Reference: 15006P/SGM

19 August 2015

**Re: EUROLEY POULTRY PRODUCTION COMPLEX (SSD 6882) – RESPONSE TO SUBMISSIONS ON
TRAFFIC AND ROAD DESIGN-RELATED MATTERS**

FIGURE SK02

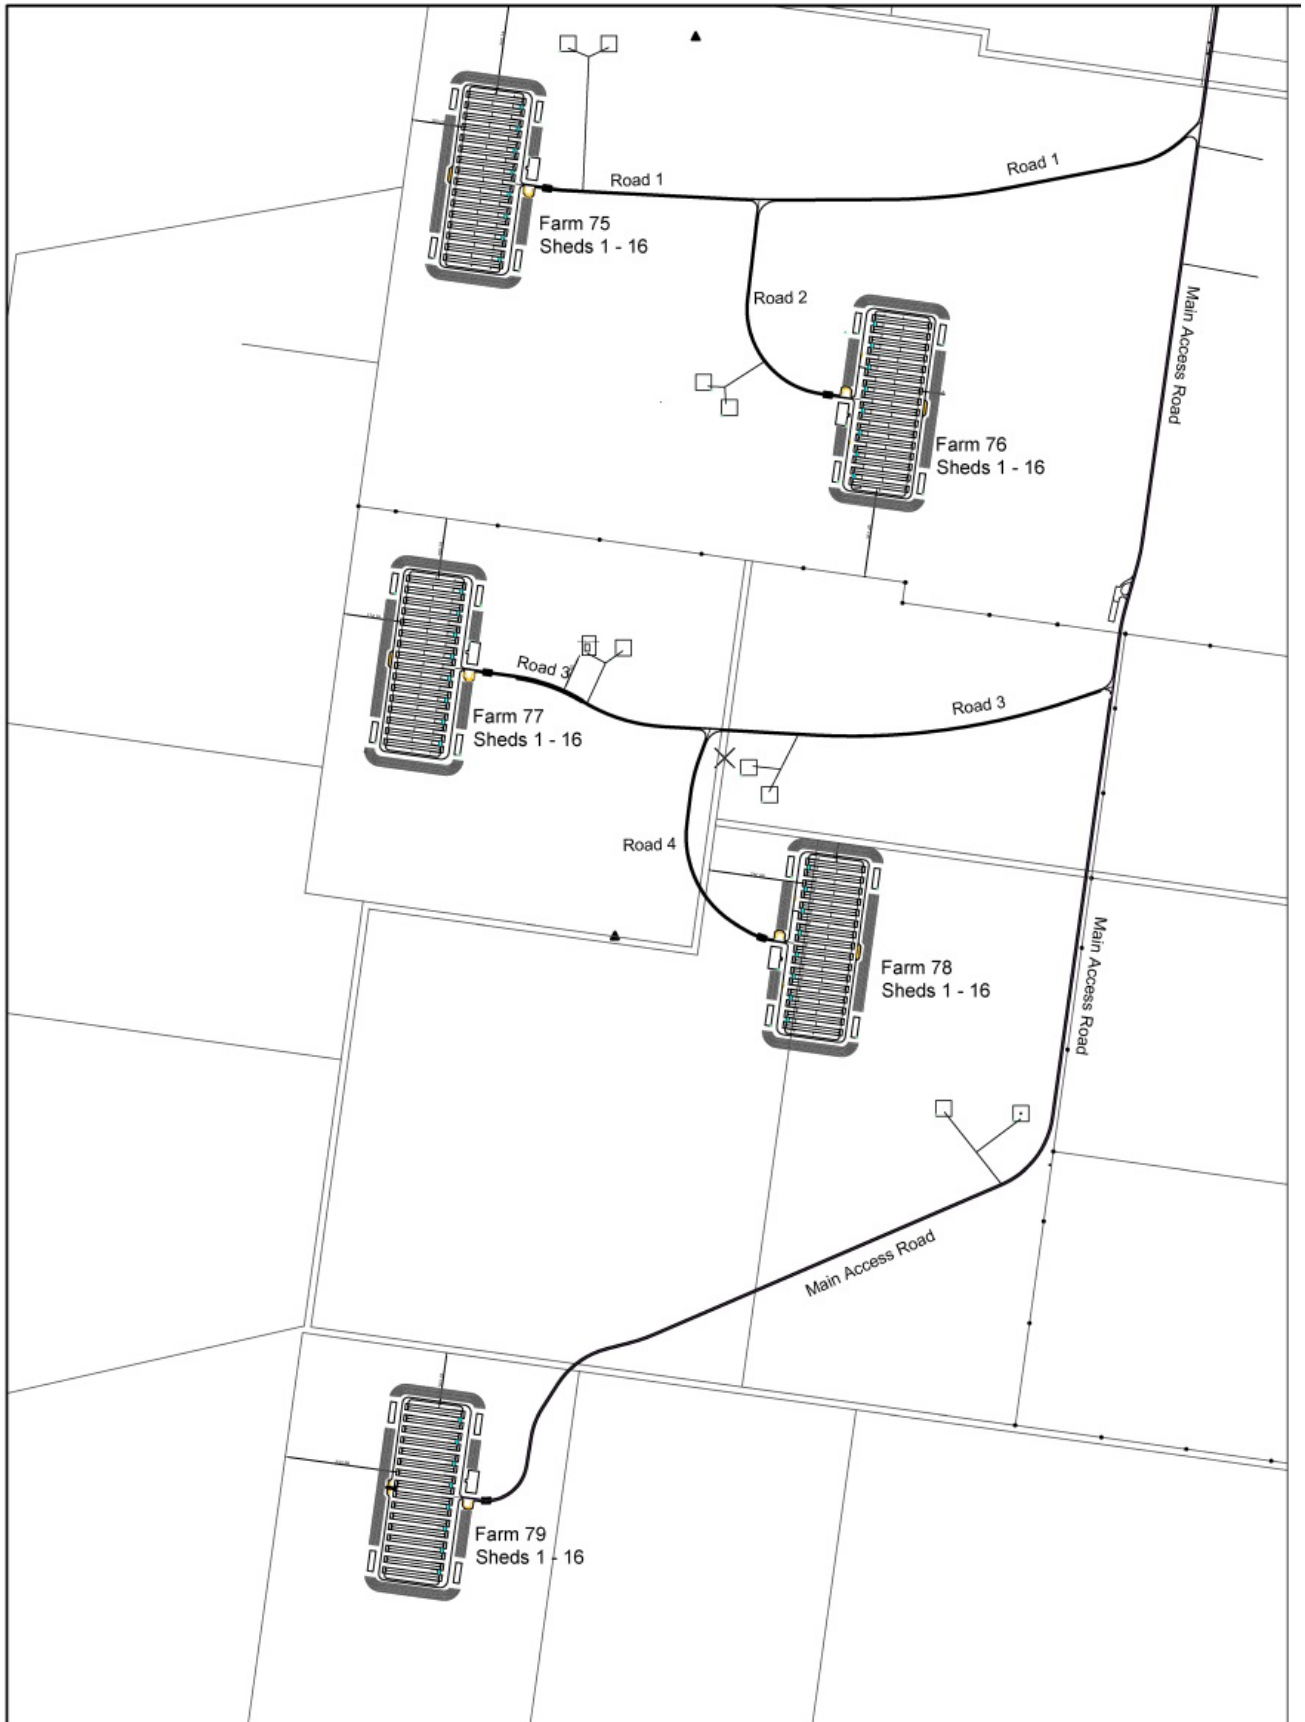
- b) *Provide additional detail on the potential impacts and potential road treatment for the intersection upgrades for the existing driveway to Lot 30 DP 7500876. Management measures for potential traffic impacts on the driveway during construction and operation are required.*

e) Ability of the proposed intersection design to accommodate road train manoeuvres at the intersection

- h) *Ability of the new intersection to manage vehicles entering from both access roads north and south of the Sturt Highway, and associated impacts on road safety for the driving public (i.e. general traffic)*

A new intersection between the Sturt Highway and the access driveway to the proposed development is proposed on the southern side of the Sturt Highway opposite the existing access driveway to Lot 30 DP 7500876 (Lot 30). In accordance with *Austroads Guide to Road Design, Part 4A: Unsignalised and Signalised Intersections*, the new intersection requires a BAL treatment to be provided for westbound traffic turning left into the proposed development's access driveway and a BAR treatment for eastbound traffic to pass a vehicle waiting to turn right into the driveway.

The new intersection will retain the lane widths currently provided for through traffic on the Sturt Highway in each direction commensurate with its designation as both a B-Double Route and an Approved Road Train Route. The intersection will also be designed to allow vehicles up to the size of B-Doubles to turn in and out of the proposed access driveway simultaneously without impacting on the safety of other road users.

For traffic entering the access driveways from the Sturt Highway, in addition to the BAL and BAR treatments proposed as part of the new access driveway, the intersection will be designed to allow for right turning movements to occur simultaneously from either approach of the Sturt Highway should the need arise. Turn path assessments will be undertaken for the proposed intersection design to ensure that the required turn paths can be accommodated satisfactorily.
